Subject: RE: Y/65/22/DOC & Y/129/22/DOC

Please see Engineers comments on Y/65/22/DOC attached.

Condition 13

Condition 15 - Maintenance

TITLE: Proposed Drainage and Levels Layout Plan
Phase 1 - Whole Site

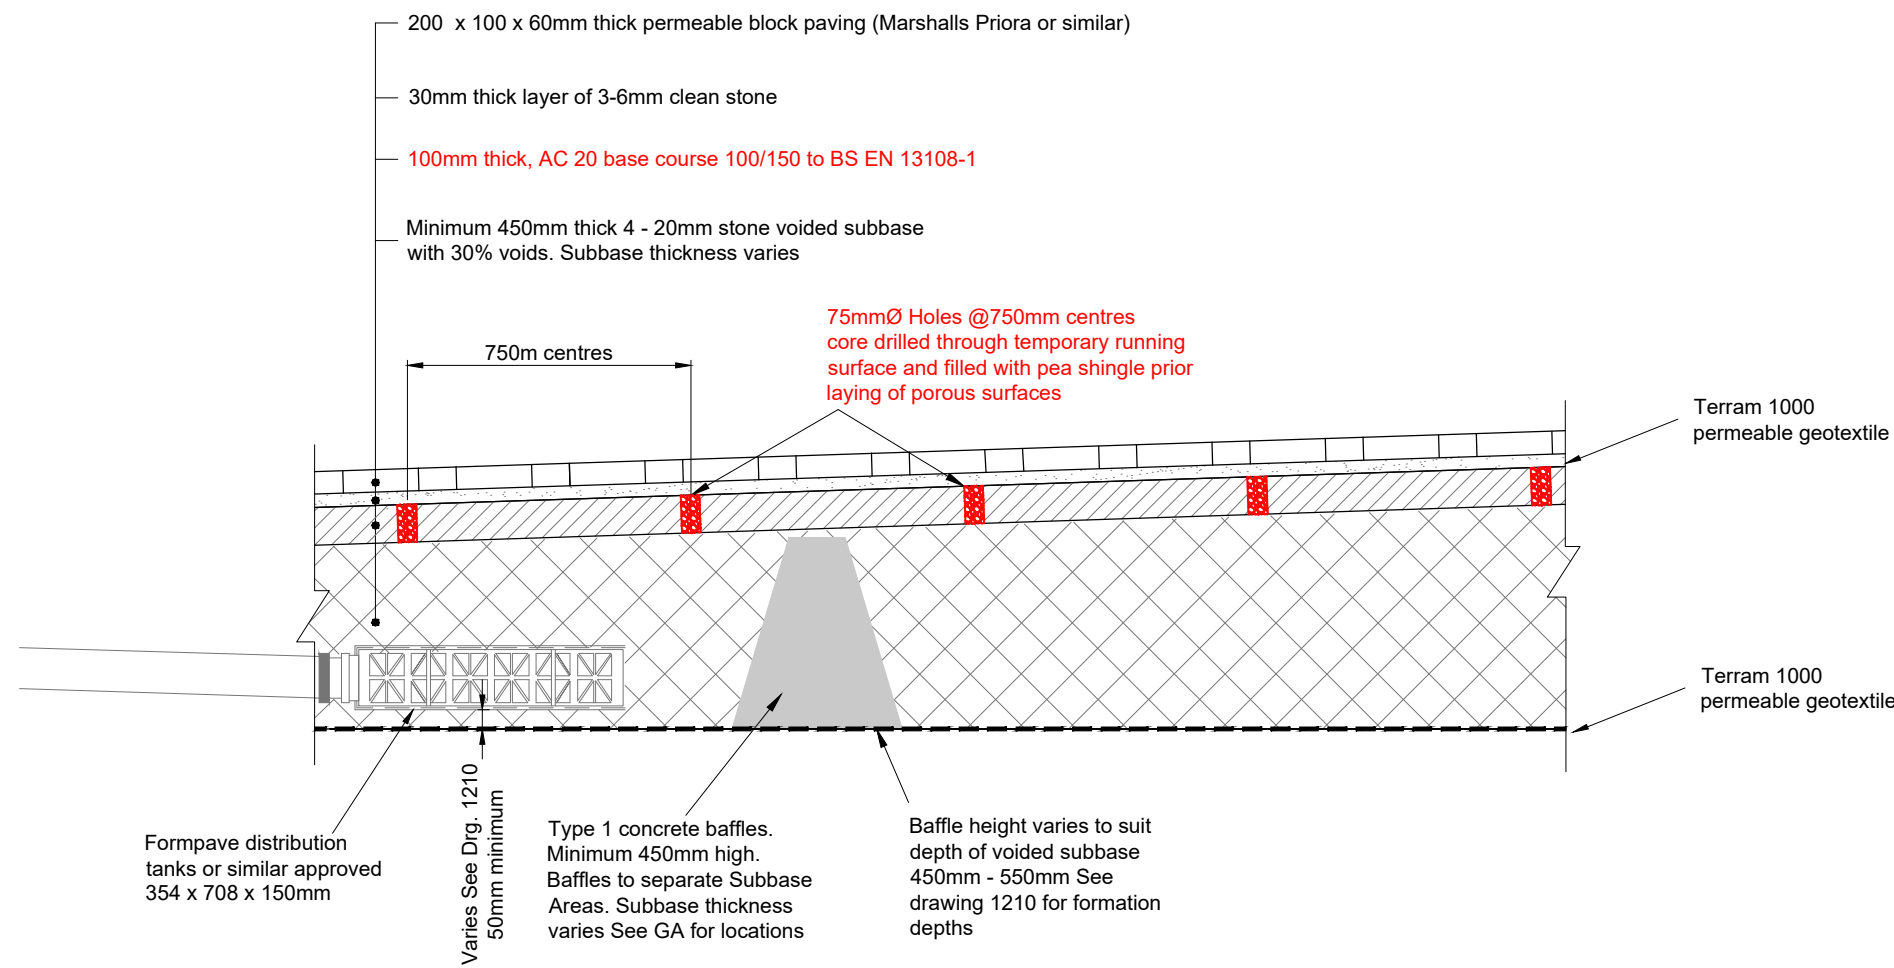
2. The verification report notes several inaccuracies with the as-built drawings. The as-built drawings should be updated to reflect what has actually been constructed.

No verification has been provided, the applicant has cited our (Arun DC) guidance for post construction verification being acceptable. Please may we have a copy of this email, including the attachments, as we believe this may be a misunderstanding of our questions, or the guidance.

PERMEABLE CONCRETE BLOCK PAVING CARRIAGEWAY & DRIVE CONSTRUCTION DETAIL
Scale 1:20

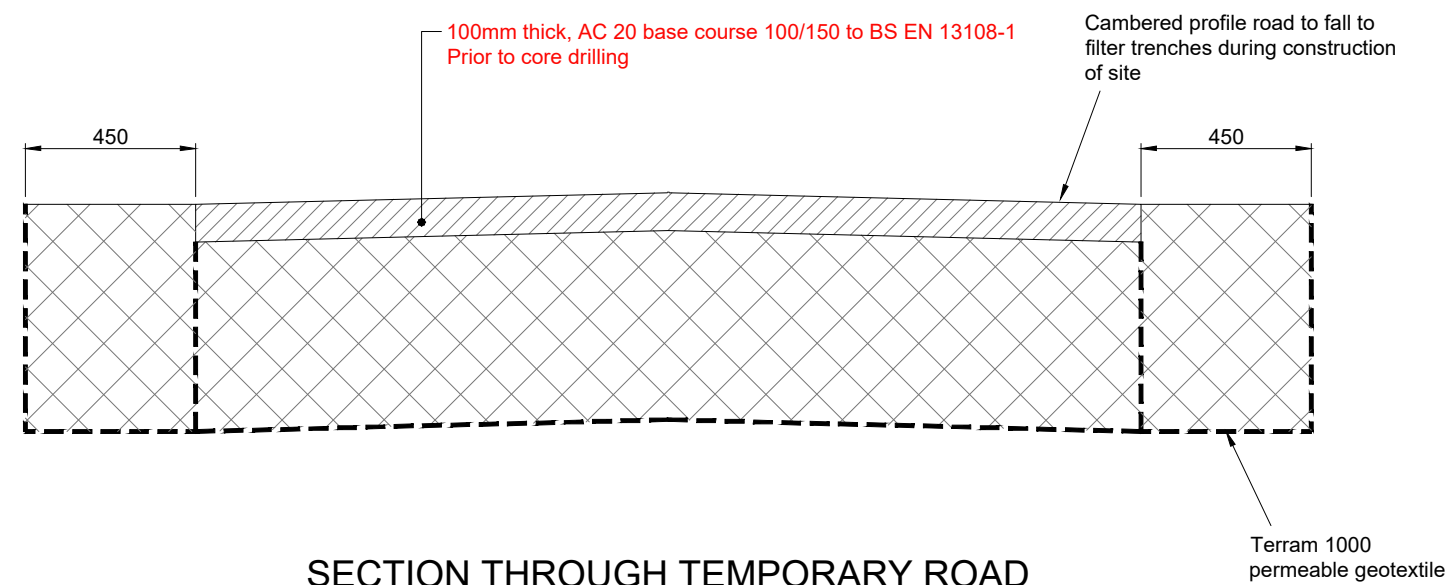
1. The applicant has stated "A 30% void ratio has been assumed for the volumes used for storage" and "Details for construction of these beddings has not been provided within the construction details in the technical note provided, nor could it be verified during the site visit."

We request evidence be provided to demonstrate that a suitable low fines 30% (or greater void ratio) aggregate has been used. This evidence can be provided in the form of receipts, further surveys, or any other method for confirming the product used for the sub-base was of a suitable quality.

This point has been addressed by applicant and confirmation that 30% porous sub-base used provided.

The evidence is included in the email from the 5th of October 2022, which includes attachments. Having checked this we can confirm receipts for low fines gravel have been provided.

CATCHPIT CHAMBER
(Scale 1:20)

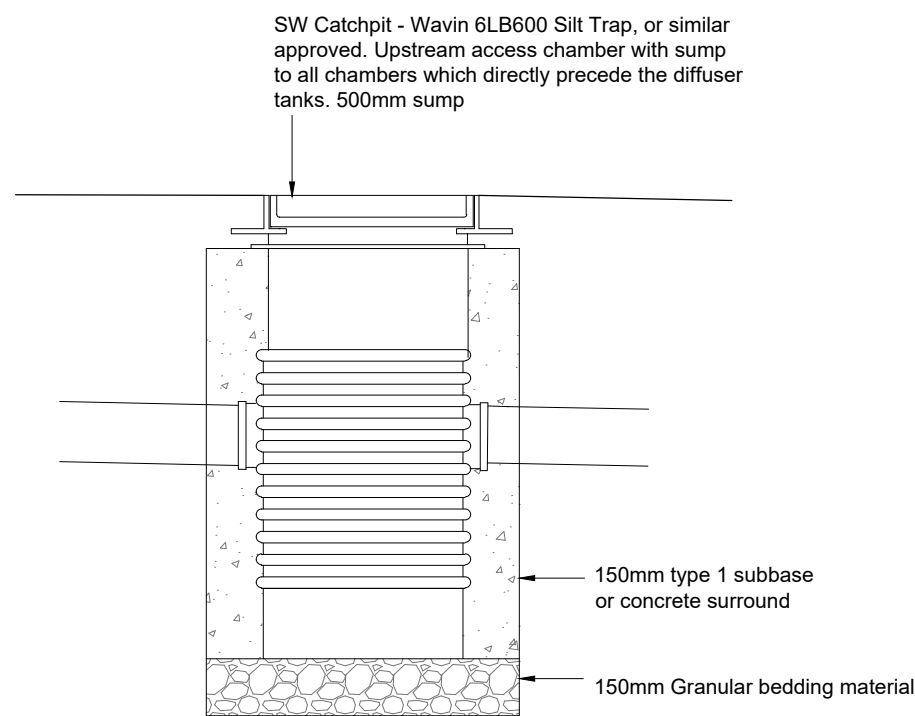
4. The bedding material and granular surround on some of the catch pits could not be confirmed and is stated as 'unknown' in the verification report. In addition, the photographs do not clearly show the quality of the installation of the inlet and outlet pipes in each catchpit, meaning it is not possible to confirm whether they are adequately sealed. Further clarification on the construction of the catch pits should be provided once construction has been completed (this can be provided as part of the final survey, point 5 below).

The email from the 5th of October 2022 should have also included an attachment showing the concrete base. Having checked this email, the concrete base photograph does not appear to have been included.
